83-2
BELT LINE 2002 GROOVING

ACC BELT LINE Rd. 2002-2003

Pavement Markings

PAVEMENT GROOVING IMPROVEMENTS

BELT LINE ROAD
 PAVEMENT GROOVING IMPROVEMENTS
"PAVEMENT MARKING PLAN"
 TOWN OF ADDISON
 AUGUST, 2002

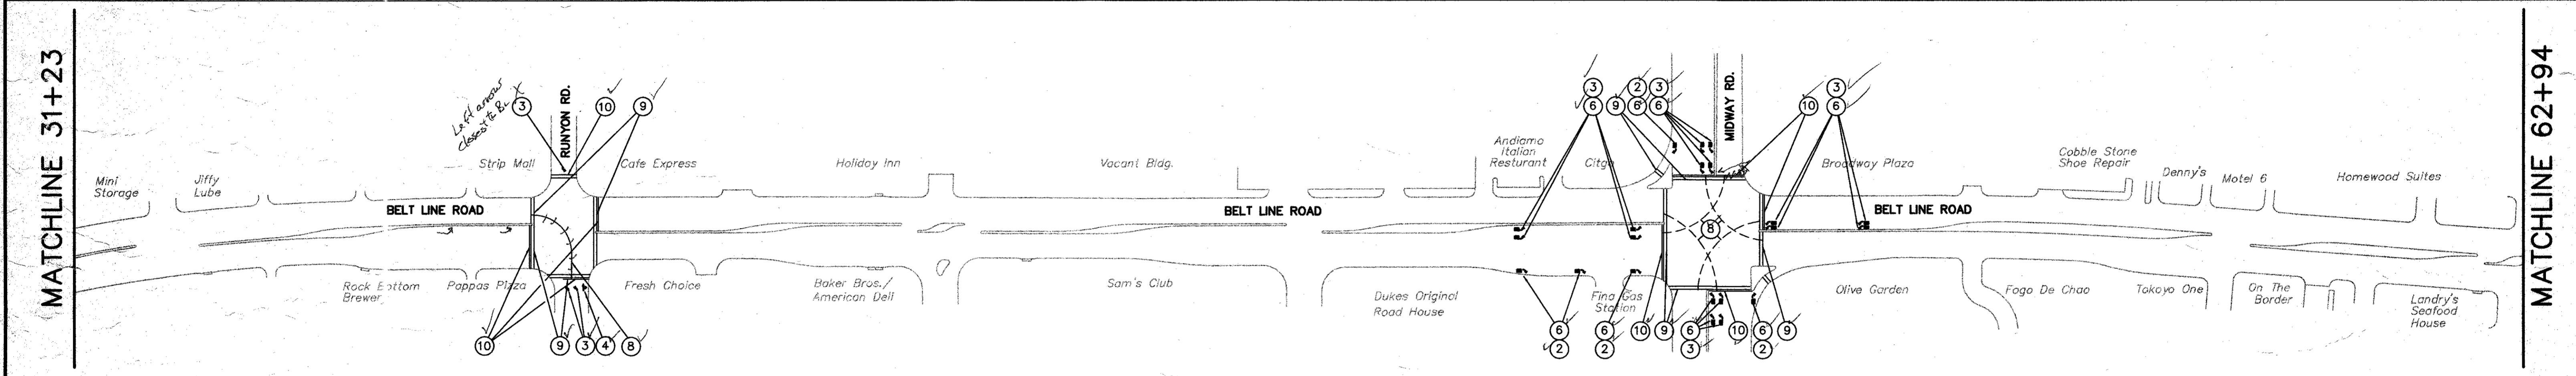
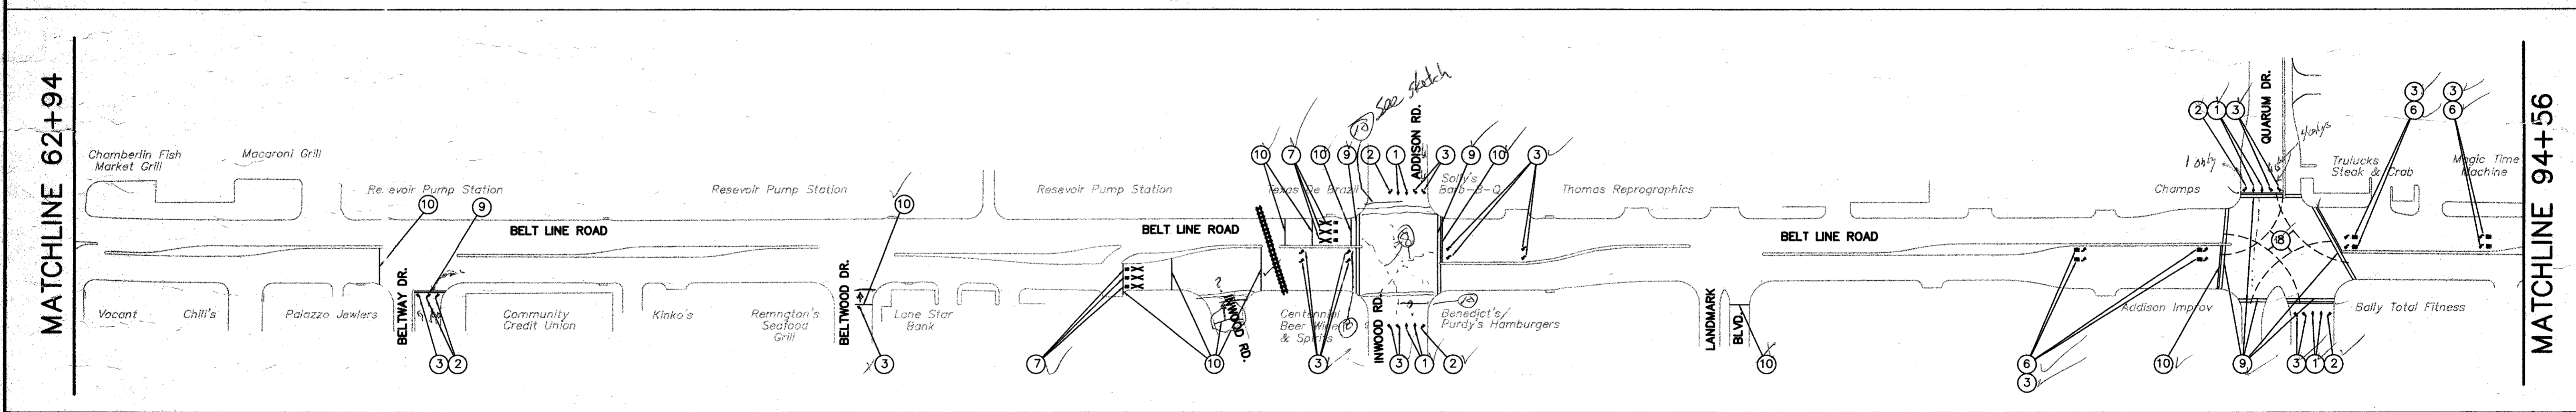
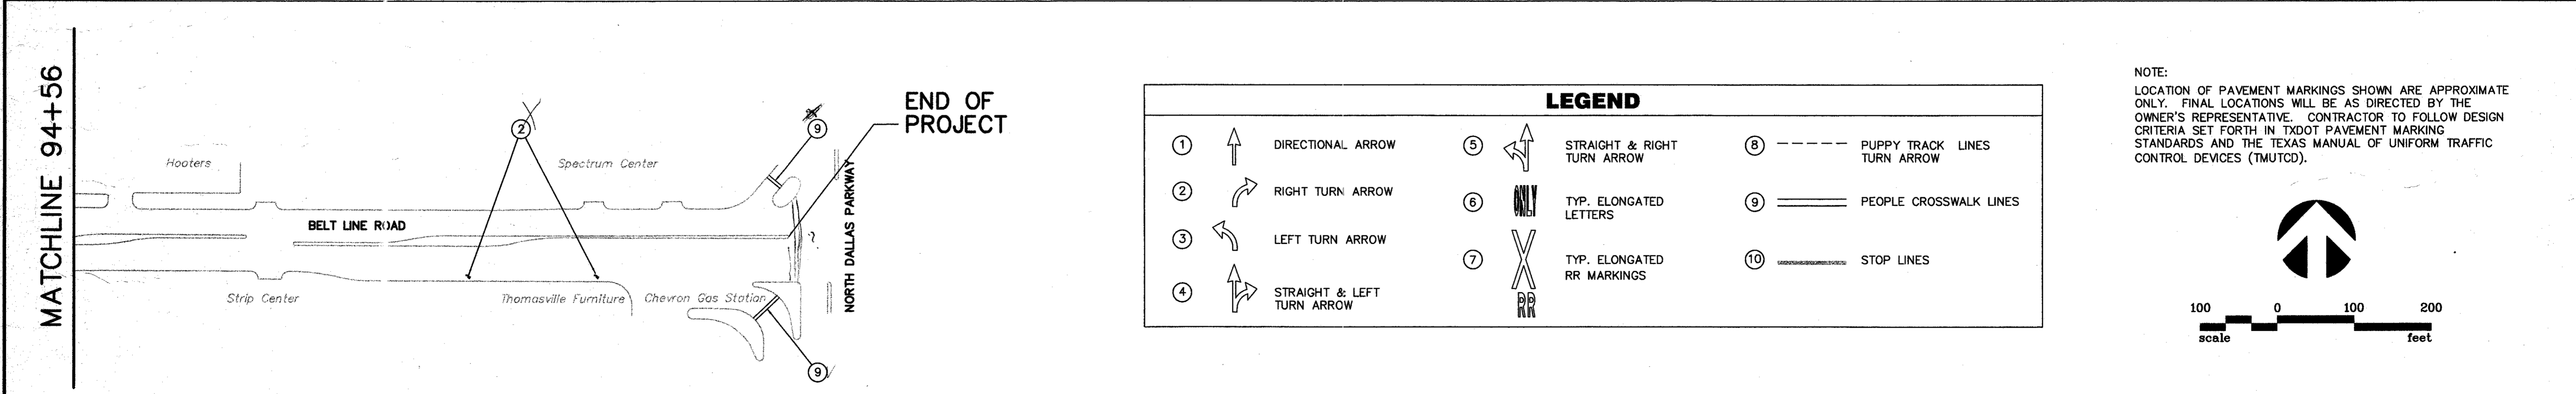
West Bound Belt Line Missing for Plan.

- 1) SB Runway - Left Turn Arrow
- 2) Local lane W of Commercial - 4 right turn Arrows
- 3) SE Business - 1 Left turn Arrow, 1 Straight/Right Arrow
- 4) Local lane @ 3711 E. - 1 Rt. arrow
- 5) WB & right lane - 2 straight/right arrows

EB Belt Line

- 1) Repair tail on arrow (first left turn arrow approaching Business)
- 2) NB Beltwood - Left arrow
- 3) NB Inwood - stop bar
- 4) NB landmark - stop bar
- 5) Local lane/Rt. turn lane approaching DP - 2 rt. turn arrows

Questions

- 1) Crosswalk @ Dallas Plum. - Atk. diff.
- 2) Crosswalk south side of Inwood/BL between Benedicts + Landanial
- 3) Stop bars @ Inwood (NB) and Beltwood (NB) should be closer to intersection
- 4) Triangle @ Shell station is hatched, but no direction given
- 5) Bold arrow @ Bayless/Harveys NE driveway, but no direction
